**Re: Auto Nation – 9100 Pan Am Freeway NE  
Erosion and Sediment Control Plan  
Engineer’s Stamp Date 6/30/2021 (B18E027)**

Based upon the information provided in your submittal received 7/26/2021, the above-referenced ESC Plan cannot be approved for Building Permit or Work Order until the following Comments are addressed.

SWPPP POSTING REQUIREMENTS.

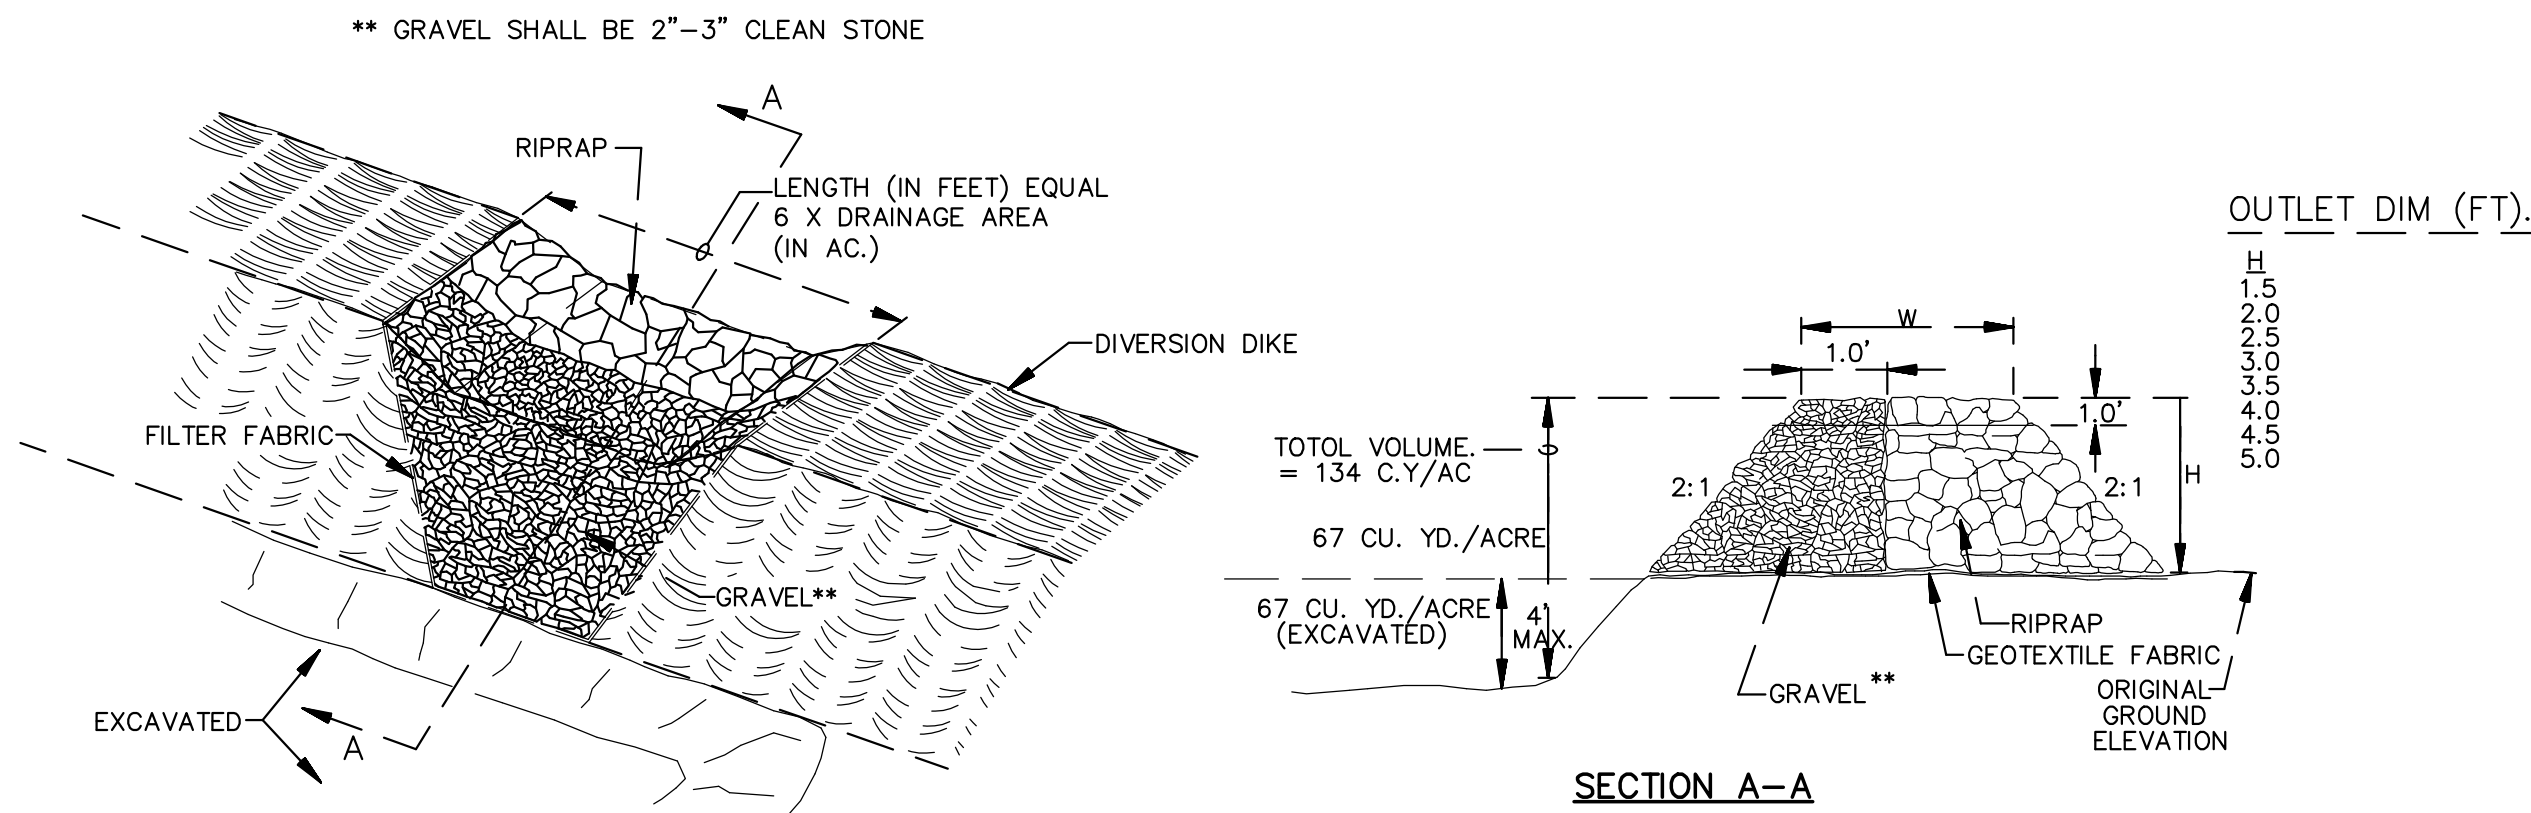
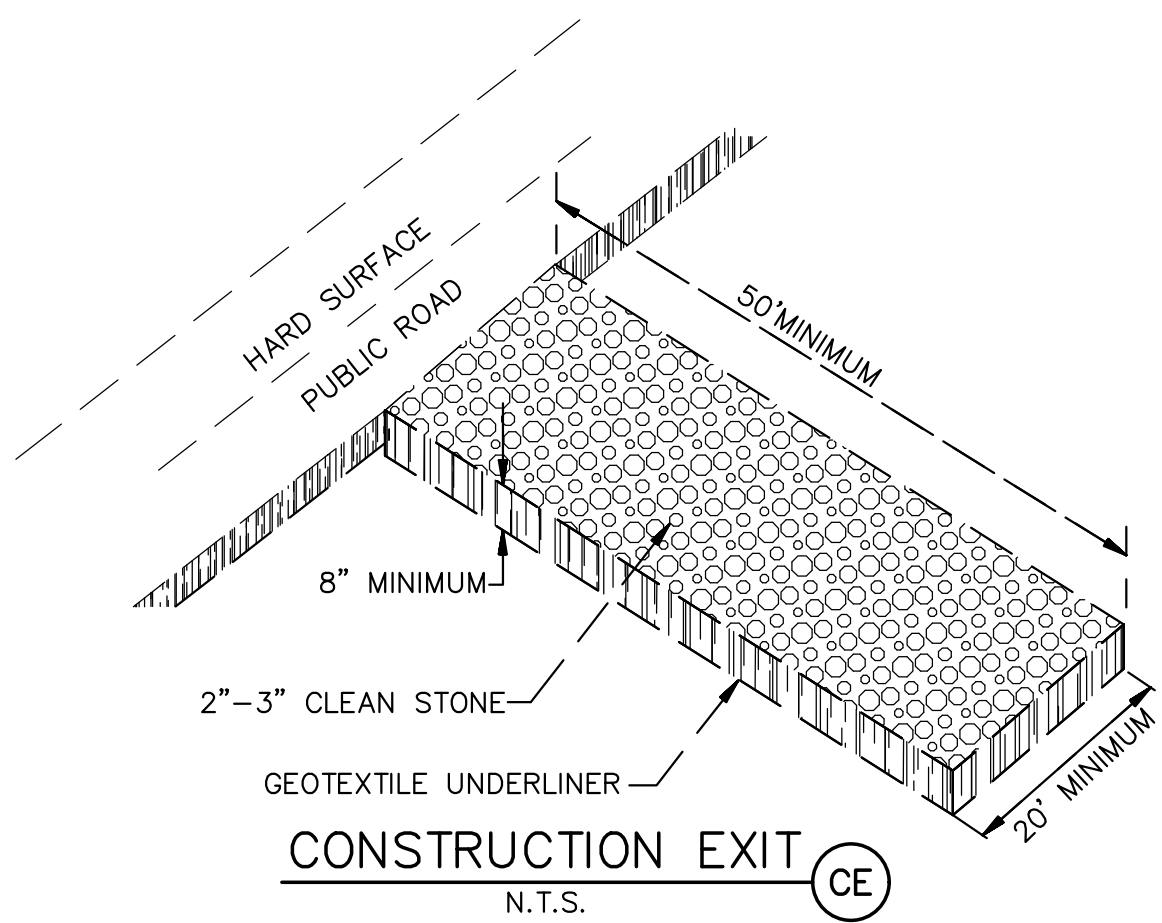
1. I can’t tell the difference between building, sidewalk, asphalt, and dirt on the ESC Plan. These structures must be clearly identified in the SWPPP per CGP 7.2.4.b.v. The same information is required in the ESC Application. You may include a copy of the Site Plan in both the SWPPP and in the ESC Application to address this requirement.

3. The “Nature and Extent of Construction Activities” on sheet SW-1 doesn’t include the building or landscaping. The disturbed area of 5.5 acres doesn’t match the NOI’s 7.25 acres. The description of Construction Support Activities may be omitted unless those areas of land-disturbing activities will occur off-site is which case the sites must be shown on the plan. Delete the paragraph on sheet SW-1 that calls for annual inspections and replace it with the inspection frequency required by the CGP. Delete the sentence that says an NOI may be transferred under the heading of “NOT Termination” since that is prohibited explicitly by CGP Appendix I.12.3.

4. The Sequence of Construction on sheet SW-1 also omits the building and the landscaping and talks about onsite roadway and installation of additional silt fence to keep sediment out of onsite roadways, which seems to apply to a different project. Under construction sequencing; 8) where are the onsite inlets? 9) Where is the onsite roadway? 10) Sediment traps will turn into permanent ponds and shouldn’t be removed. Where will the additional silt fence go?

5. The description of predevelopment conditions should say the site is covered by asphaltic paving, and the undisturbed natural state is uncompacted soil with 30% cover by native grasses and shrubs. AC removal and disposal should be added to the descriptions of the nature and the sequence of the construction project.
